From: Laura Gibbons
Sent: 04 May 2018 15:32
To: Planning.Responses
Subject: RE: Planning Consultation on: WA/26/18/OUT

APPLICATION NO: WA/26/18/OUT

Site Address: Former Lanes End House Adjacent to West Walberton Lane &
Arundel Lane Walberton BN18 0QS

Description of Works: Outline application with all matters for 6 No detached houses with detached garages. This application is a Departure from the Development Plan.

Former Lanes End - Six Six bedroom detached Houses with Garages Proposed Layout Scale 1:100 @ A3 (c) PJ Developments LTD 2018		REVISIONS		01
		MM/DD/YY	REMARKS	
	1	--/--/--	...	A
	2	--/--/--	...	
	3	--/--/--	...	
	4	--/--/--	...	
	5	--/--/--	...	
West Walberton Lane Proposal

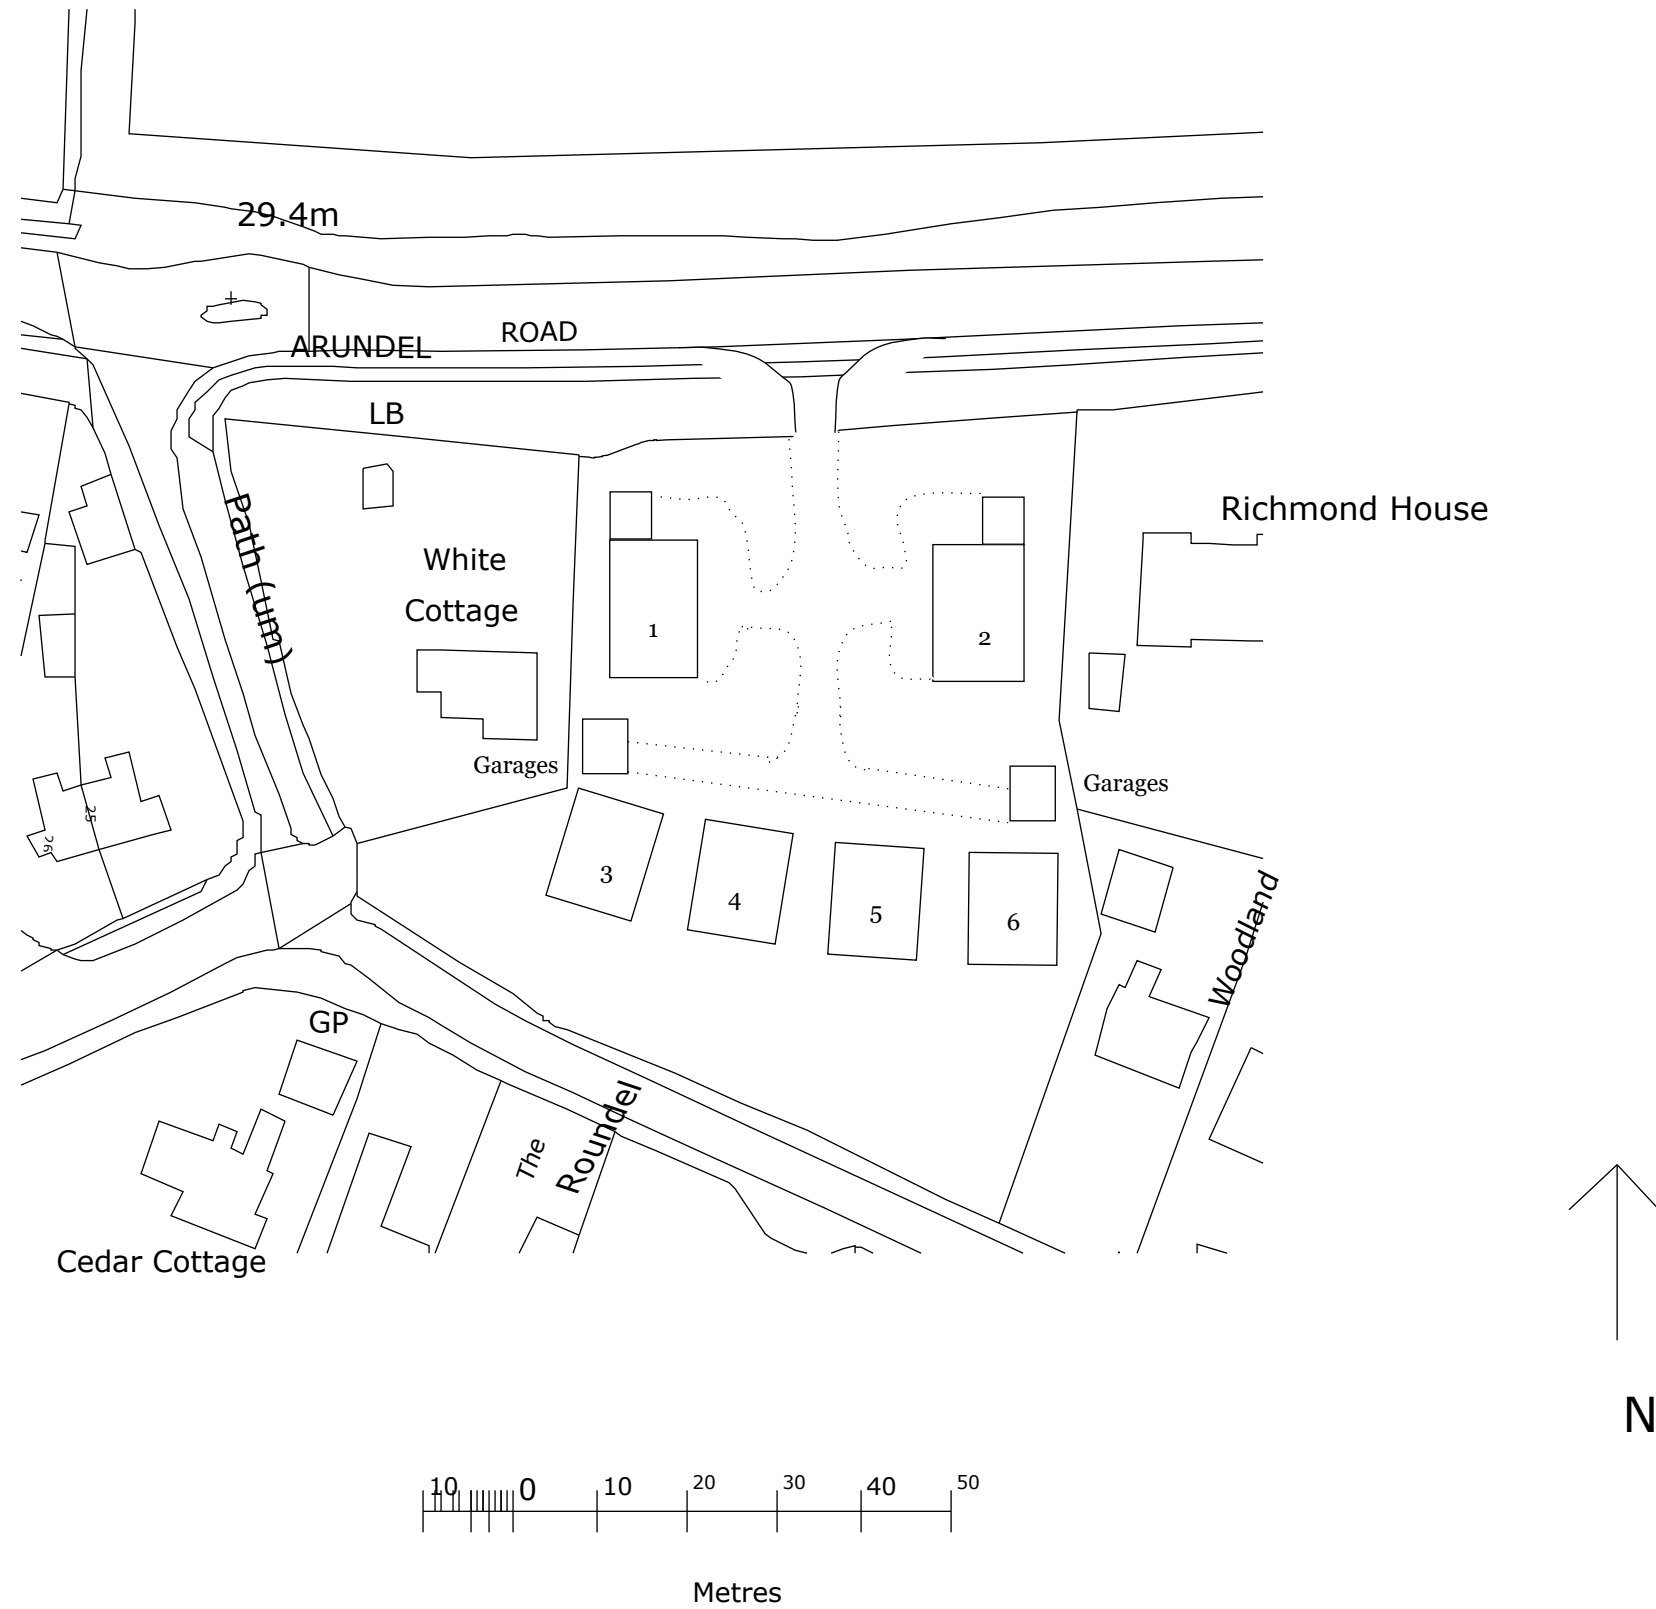
Soakaways must be investigated for surface water disposal.

Infiltration rates for soakage structures are to be based on percolation tests undertaken in the winter period and at the location and depth of the proposed structures. The percolation tests must be carried out in accordance with BRE 365, CIRIA R156 or a similar approved method and cater for the 1 in 10 year storm between the invert of the entry pipe to the soakaway, and the base of the structure. It must also have provision to ensure that there is capacity in the system to contain below ground level the 1 in 100 year event plus 40% on stored volumes, as an allowance for climate change. Adequate freeboard must be provided between the base of the soakaway structure and the highest recorded annual groundwater level identified in that location.

Any SuDS or soakaway design must include adequate groundwater monitoring data to determine the highest winter groundwater table in support of the design. The applicant is advised to discuss the extent of groundwater monitoring with the Council's Engineers. Supplementary guidance notes are also enclosed for information.
